Consultation Response from KC, Lead Local Flood Authority
2024/93036 Greenside Mills, Saville Road, Skelmanthorpe, Huddersfield, HD8 9EE
Discharge of details reserved by condition 17 (drainage) of previous outline permission 2018/91787 for demolition of existing buildings and structures and erection of residential development
Date Responded: 4th February Responding Officer: Paul Farndale Responding Ref:

Condition 17 – Drainage Details

DRAWING No: ALT170724-202-01

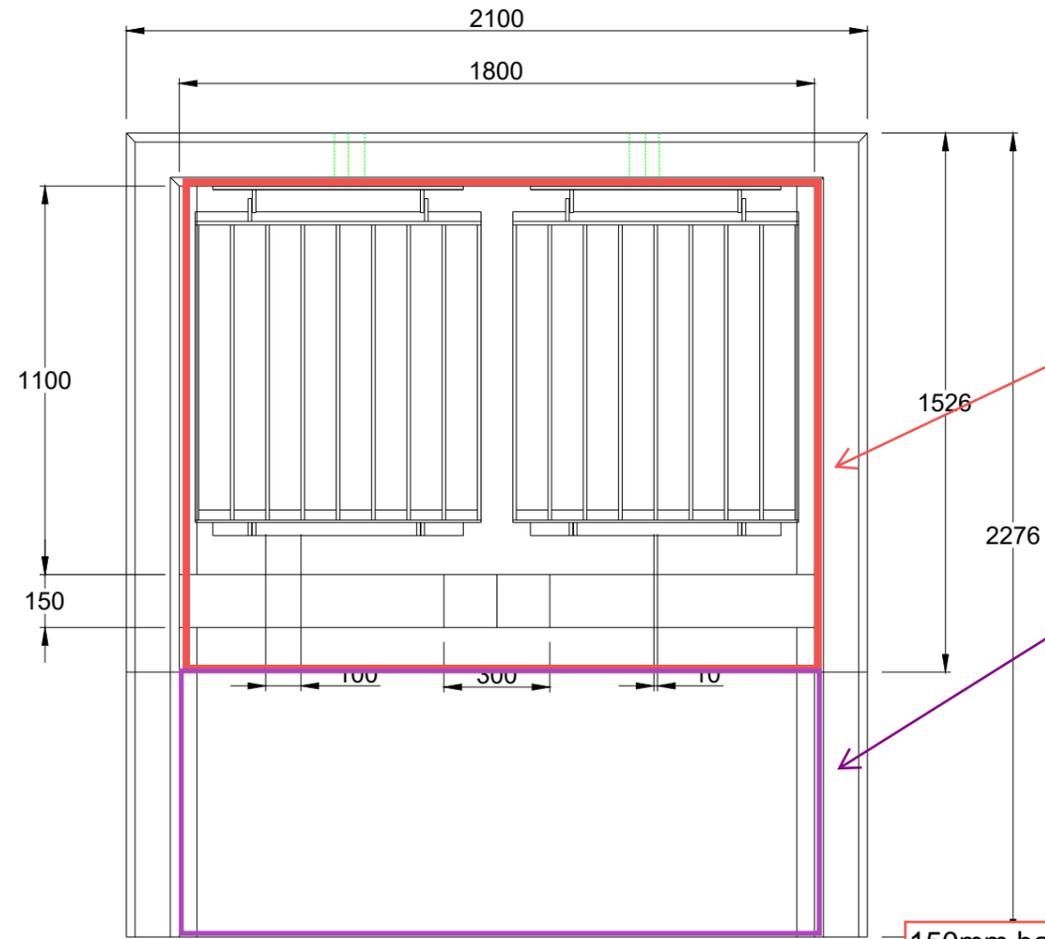
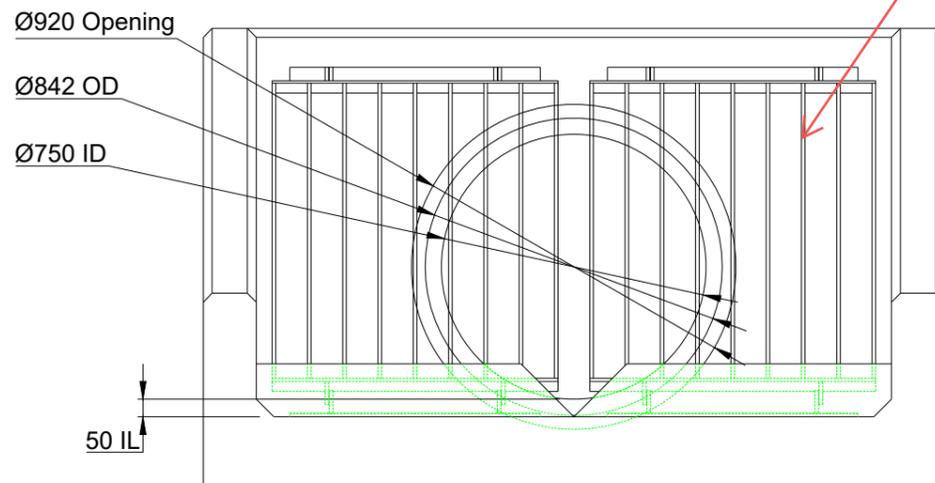
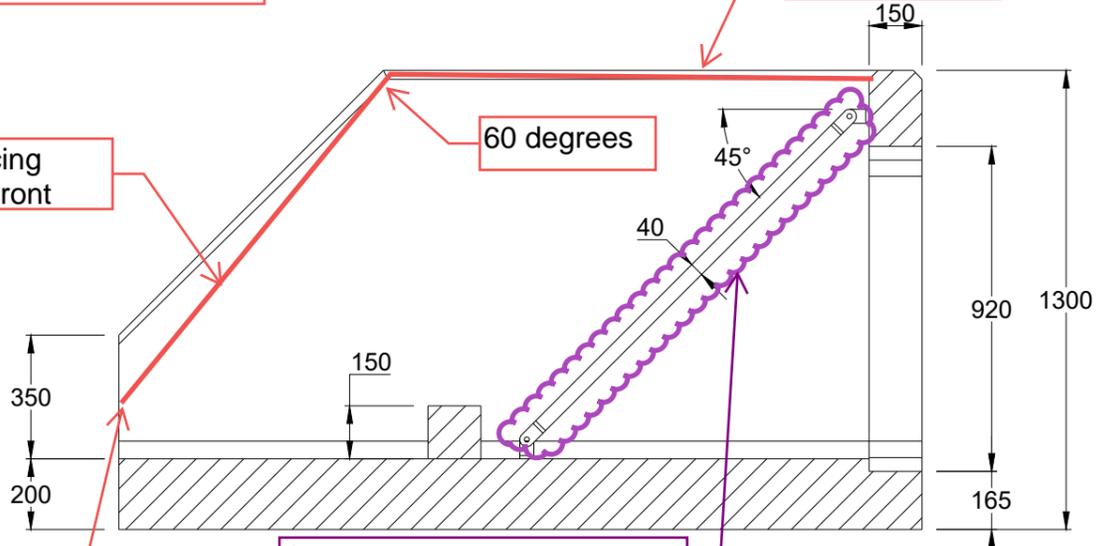
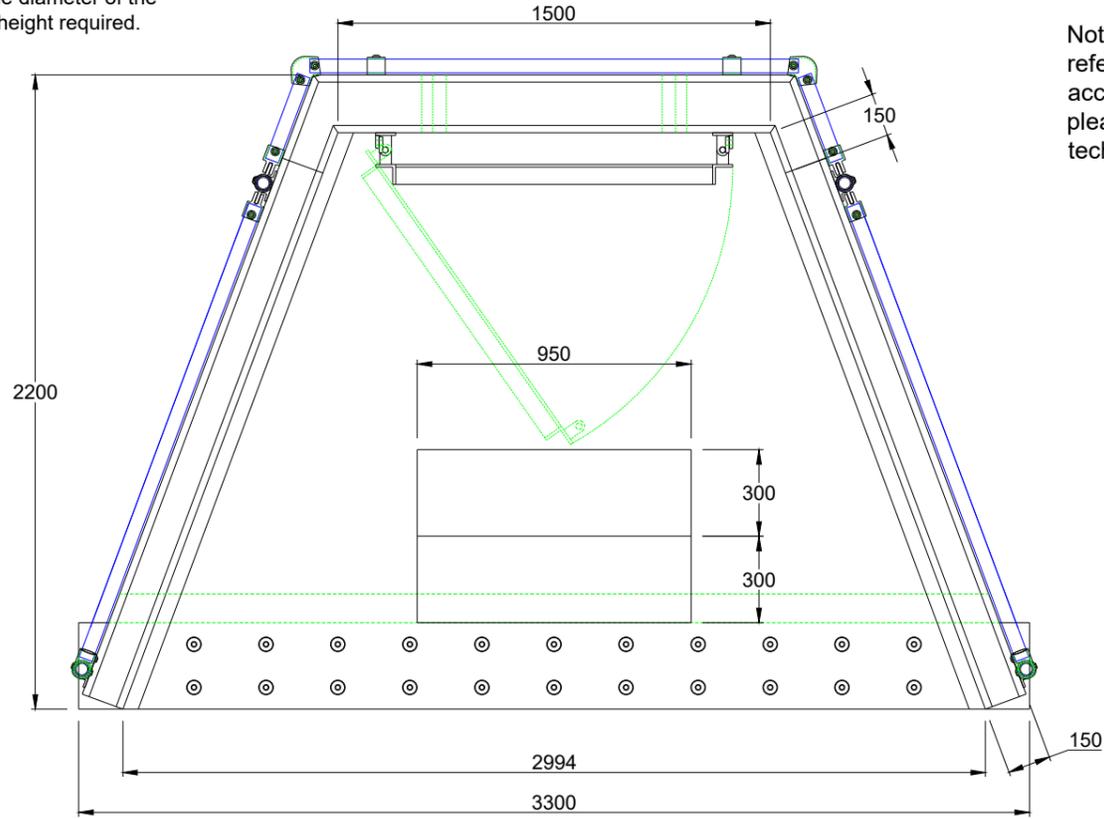
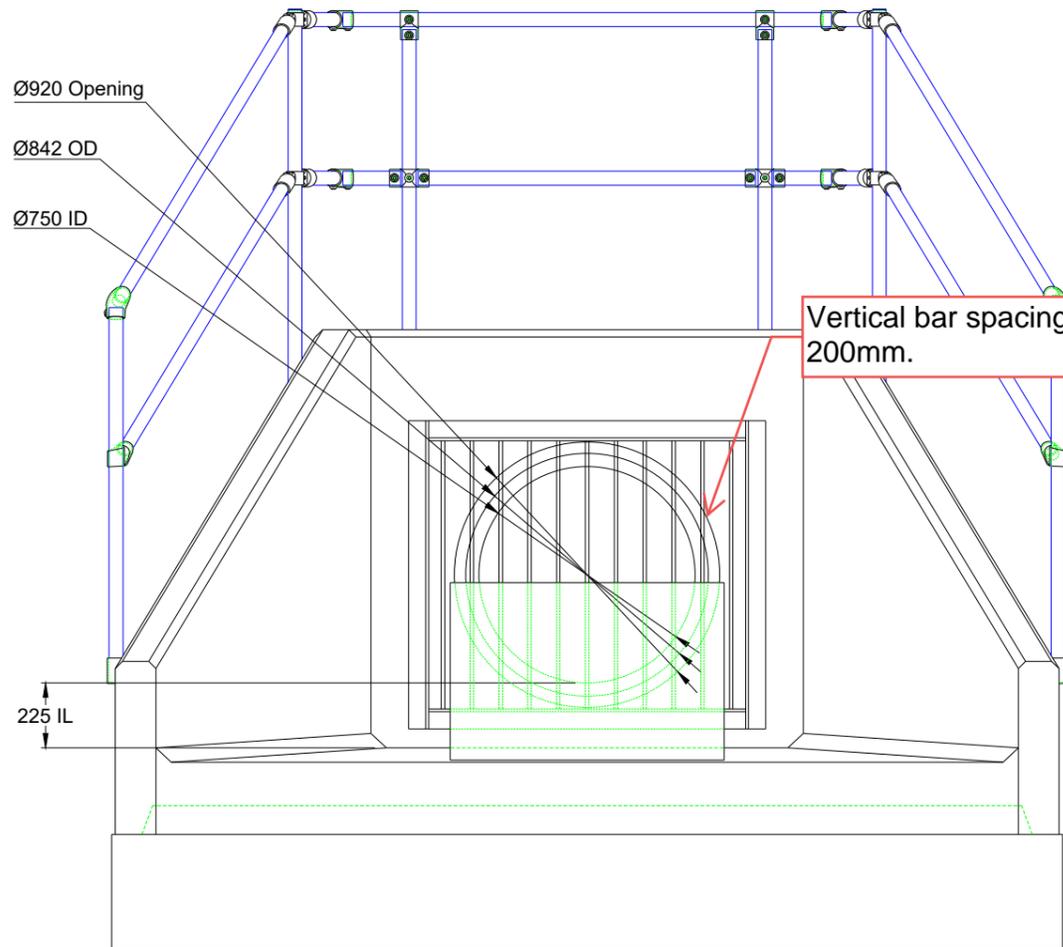
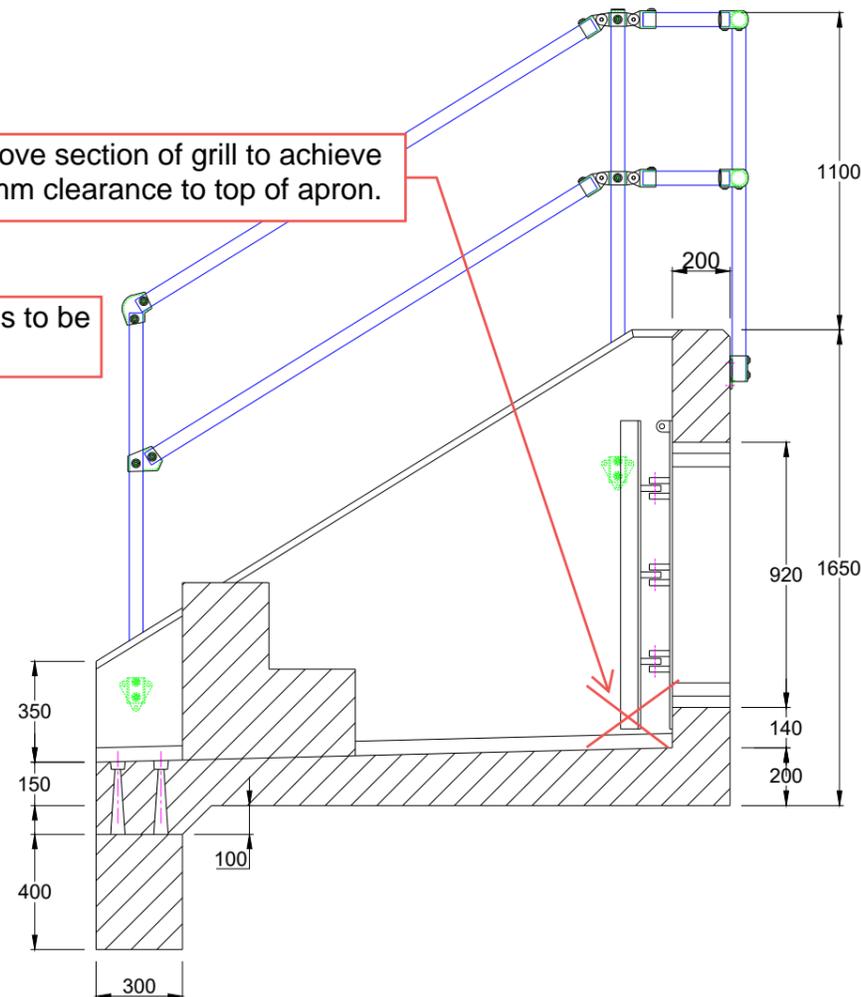
Kirklees LLFA would like slight alterations and further information regarding safety screen and trash screen design. 150mm intervals for bars are recommended as a minimum of the angled screen and safety screen. A 150mm clearance from the bed is suggested to allow passage of small debris.

Kirklees LLFA are always keen on a significant horizontal section as an overflow for trash screens. Any design however must look at how the screen will be maintained and what is a safe position for the operator to stand. This could mean a plated section on the horizontal section with 75mm open bars behind this. Please contact Martin Stephenson or Paul Farndale for advice 01484 221000.
